**Consultation Response from KC,
Trees**
2026/90300 216, Barnsley Road, Denby Dale, Huddersfield, HD8 8TU
Erection of extensions and alterations
Date Responded: 06/03/2026
Responding Officer: H Irving
Responding Ref: 08/17

Drawing Title
Tree Constraints Plan
(Inc TPO overlay)

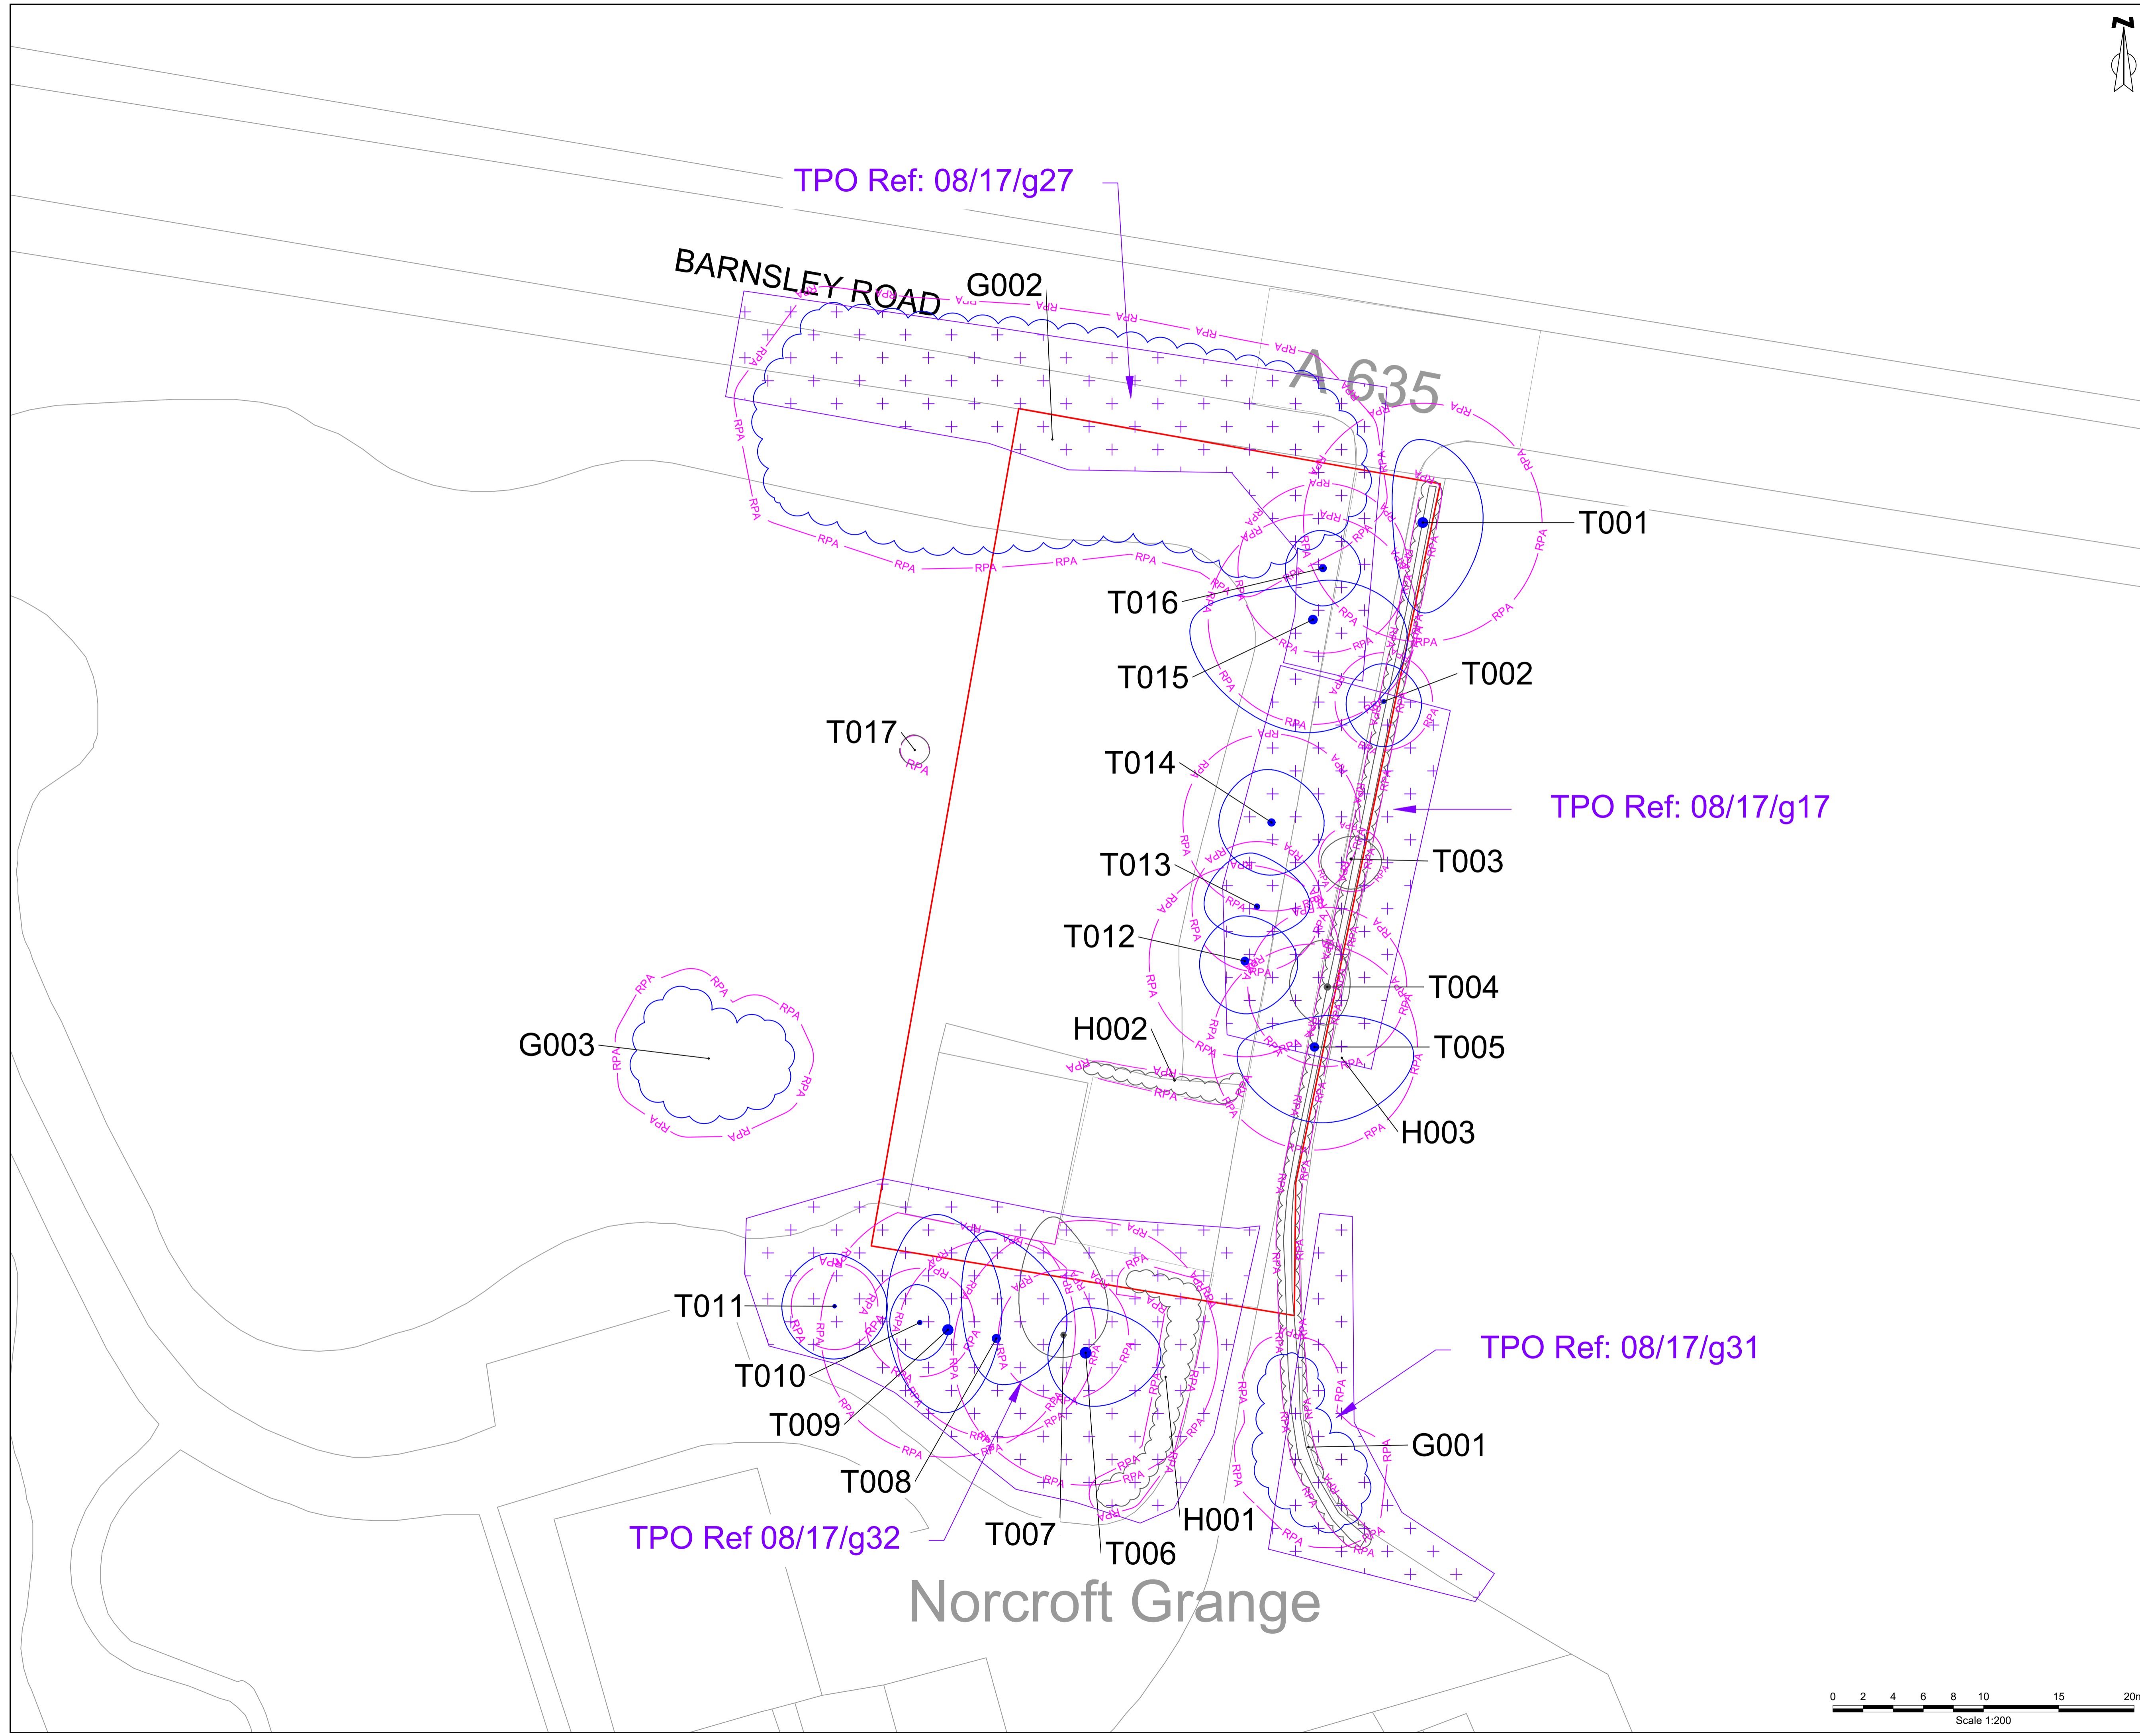
We can confirm the receipt of tree constraints plans 1 and 2, ref 9104.001-ENZ-XX-XX-DR-AR-0001. However, it appears that the tree survey report and schedule are outstanding. Additionally, all planning applications which may impact trees must also be supported by an Arboricultural Impact Assessment and Tree Impacts Plan, as per BS5837:2012 *trees in relation to design, demolition and construction recommendations* and the planning guidance, available on the Kirklees Council website. Please see below:

There is a holding objection from an arboricultural perspective. The proposal conflicts with adopted Kirklees local plan policy 33 and 24 (i). We cannot progress this planning application until the required details are supplied and approved. Please provide a full tree survey and AIA as soon as possible.
